Our ref: Huntlee New Town - Stage 2 (SSD-70748466)

17 October 2025

Subject: Request for Additional Information

HUNTLEE STAGE 2 DA VILLAGE 2
CENTRAL & SOUTH DETAILED
SUBDIVISION BAL PLAN (3)

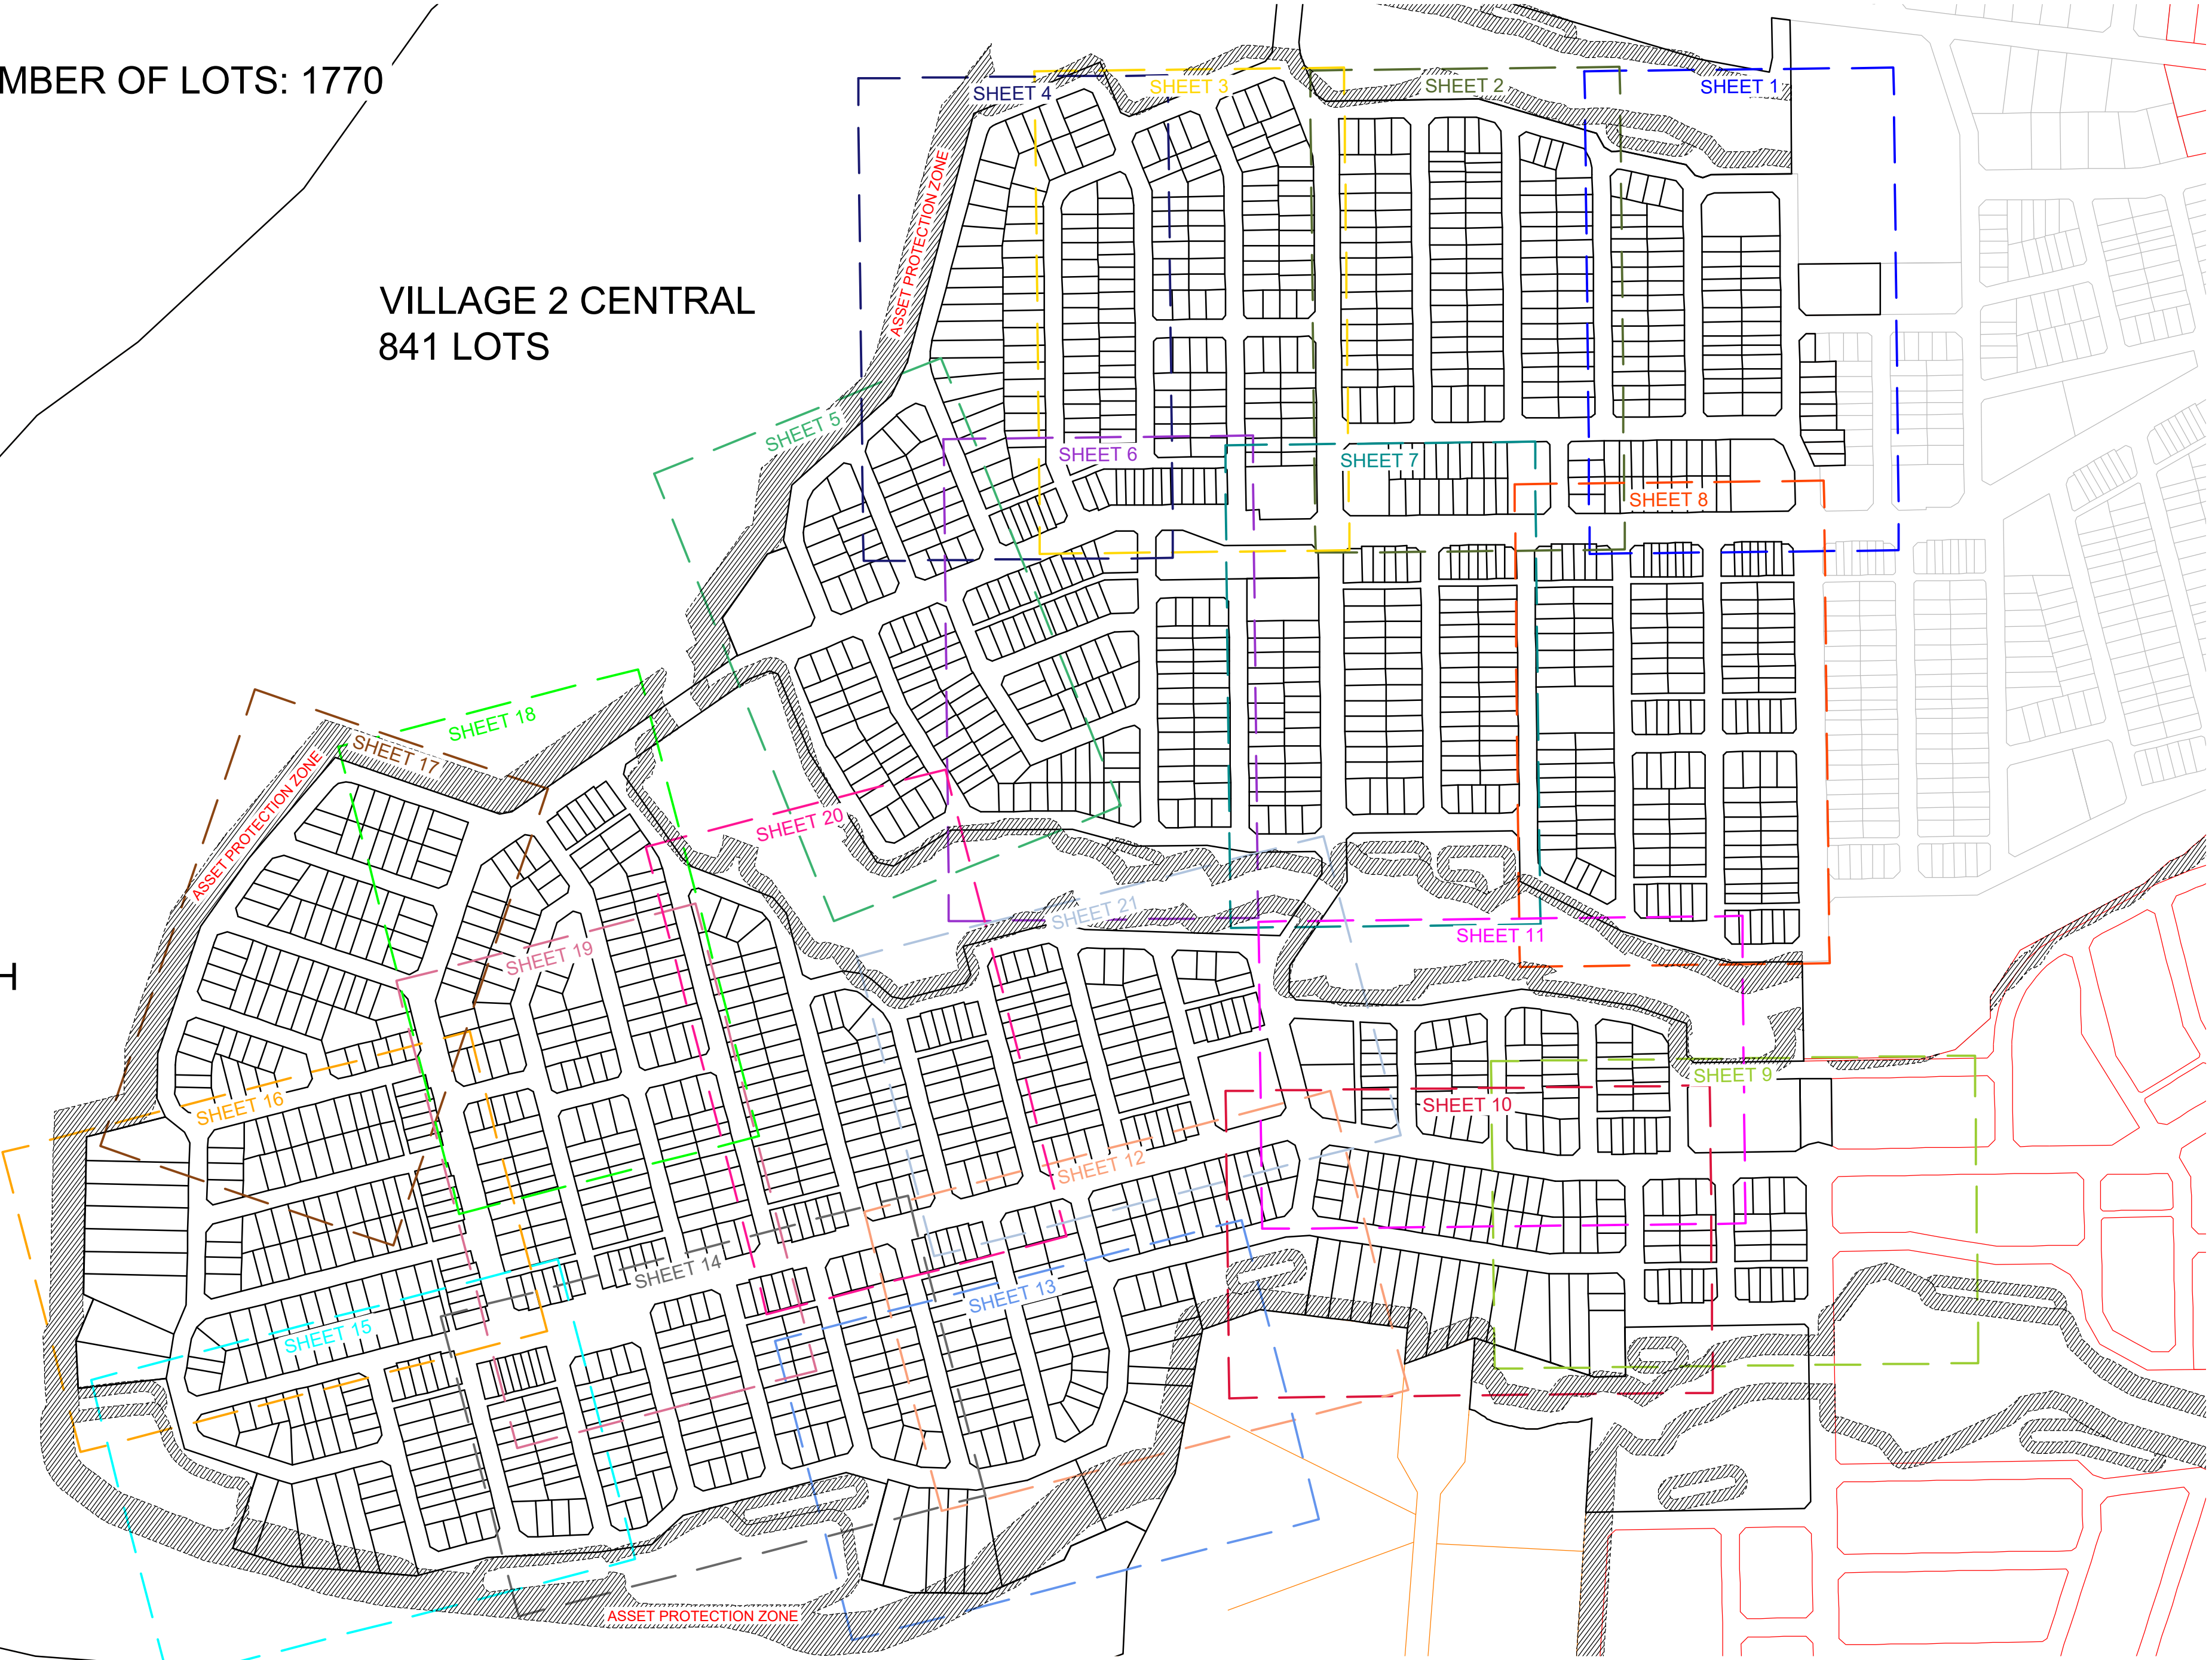
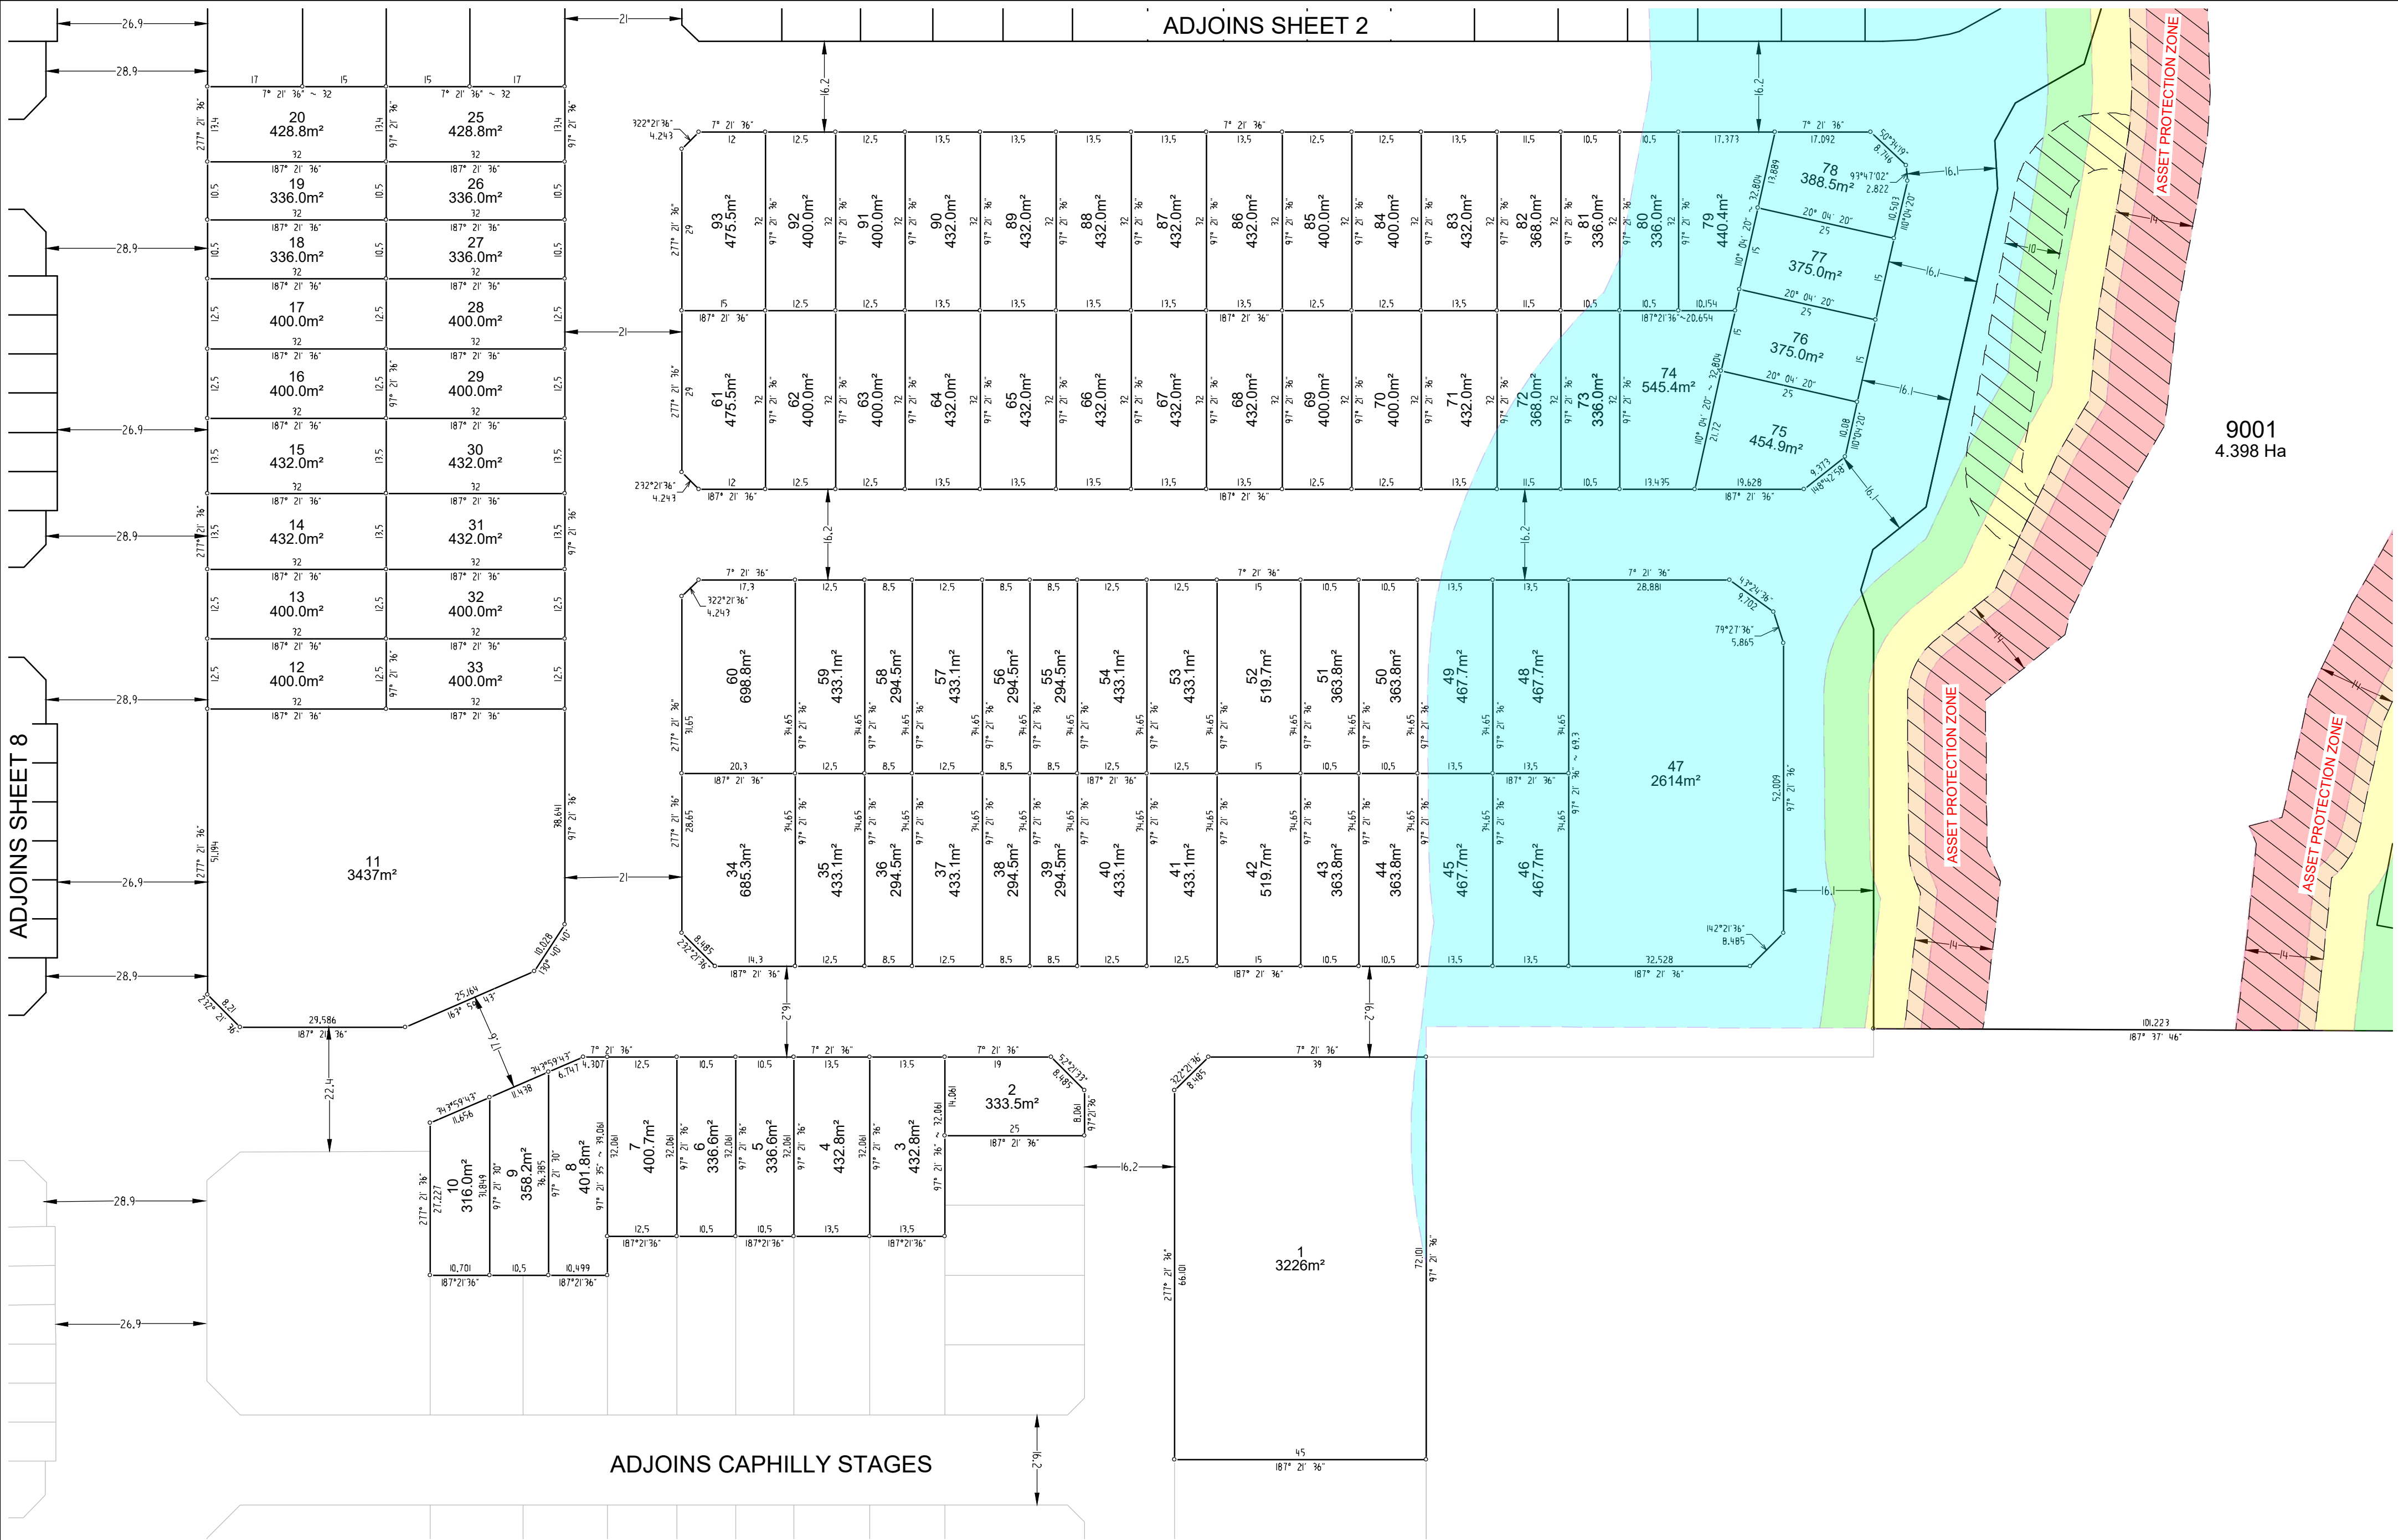
- the proposed ongoing management arrangements for the bio retention basins. The vegetation within these basins is required to be assessed as part of the hazard unless it is intended to be managed as an inner protection area in perpetuity
- bushfire attack levels (BAL) for future dwellings on lots within Village 2. Please provide a BAL table and plan identifying the lot numbers and applicable BAL ratings for future dwellings
